Technical Note

Project No: ITB14224
Project Title: Nursery Fields
Title: ITB14224-015
Ref: LHA and PROW Response
Date: 25 February 2021

- 1.1 Landform Bersted Ltd (Landform) has submitted a planning application to Arun District Council (ADC) for 225 new homes on land to the north of Chalcraft Lane known as Nursery Fields (planning ref: BE/148/20).

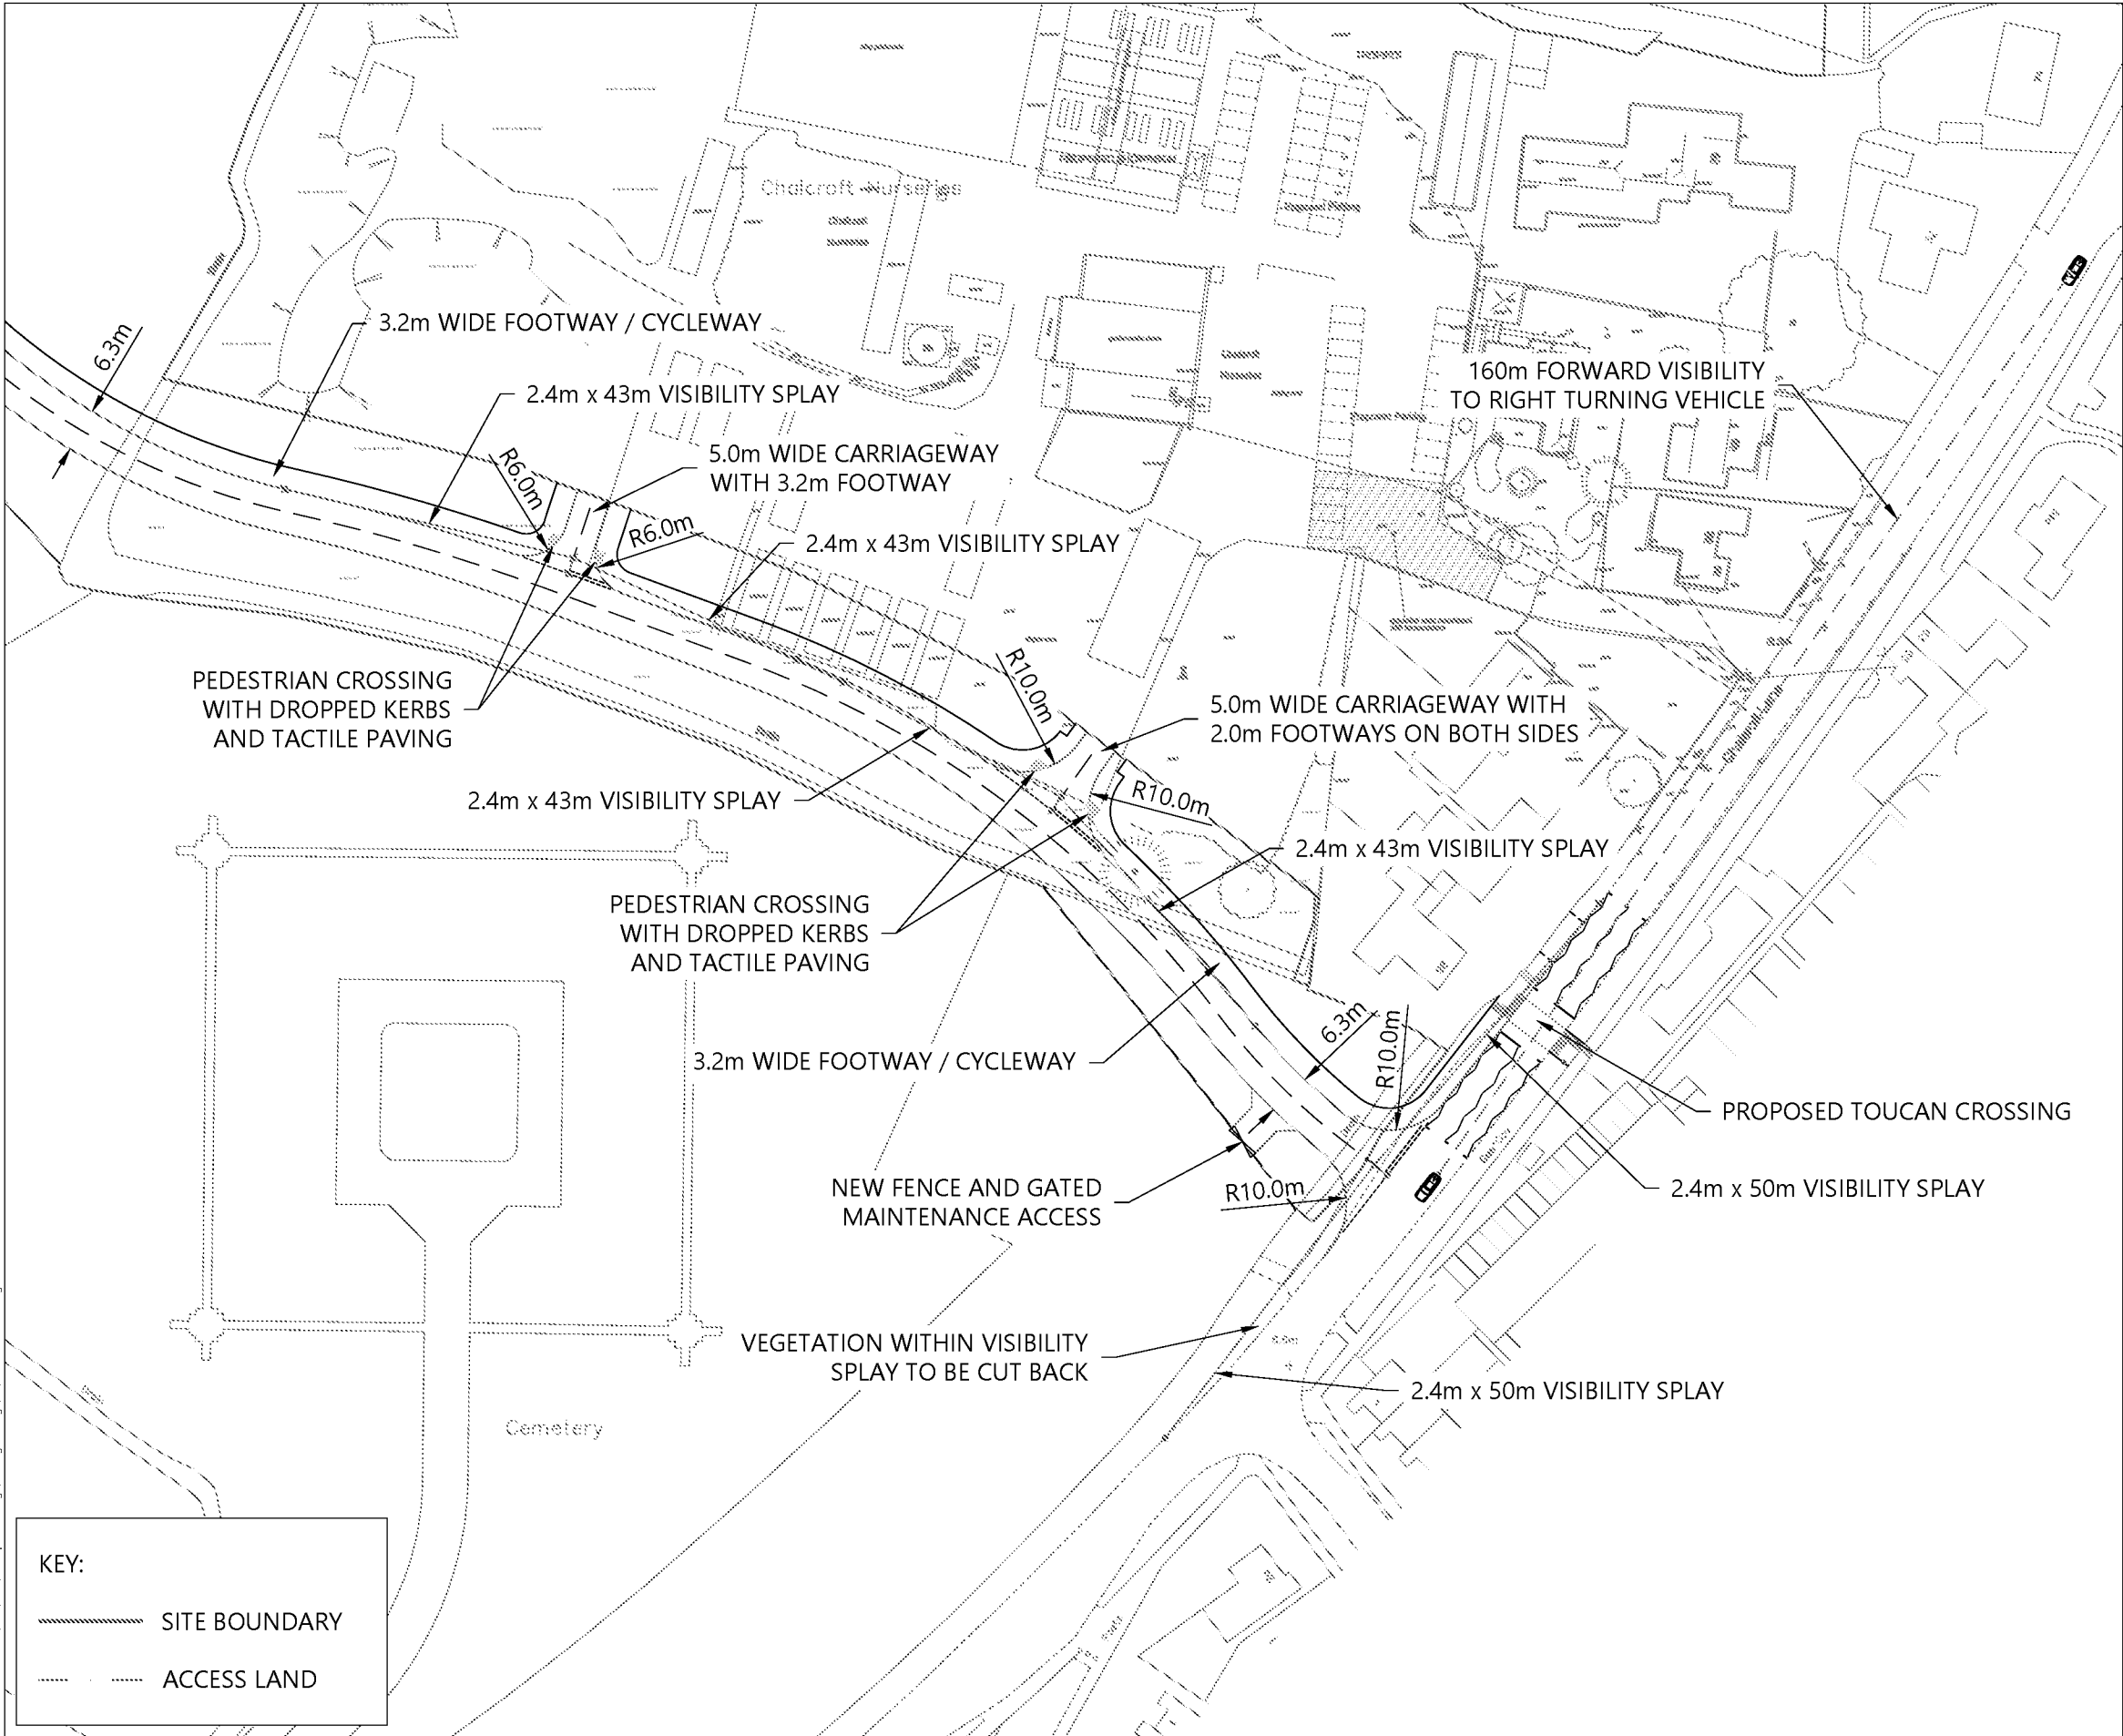
- 2.4.1 WSCC has requested that the cycle infrastructure adjacent to the site access road and the associated infrastructure along Chalcraft Lane (including a Toucan crossing) is removed, focussing cycle access

towards the community centre access road and existing cycle infrastructure along this corridor towards Bognor Regis.

25. It's recommended that this aspect (namely the provision of shared use facility within the development, the Toucan crossing, and the proposed widening works along Chalcraft Lane) of the application is either removed or reassessed and amended to ensure compliance with LTN 1/20. In the event this southern route is removed, the Green Infrastructure Parameter Plan would need to be updated.

- 2.4.2 The site access drawing has been amended to reflect these amendments and the revised arrangements are presented as **Drawing ITB14224-GA-009 Rev B**. Similarly, the Land Use Parameter Plan and the Green Infrastructure Plan have also been updated and copies of these are provided at **Appendix C**.

- 4.4 The pedestrian and cycle access arrangement has been amended in accordance with the request of WSCC. The Toucan crossing and associated cycle infrastructure has been removed, to focus movements toward the existing cycling corridor. Confirmation has been provided by the Road Safety Auditor that the site access arrangements have been audited on the basis of access being provided to both the Chalcraft Nursery and Nursery Fields developments.
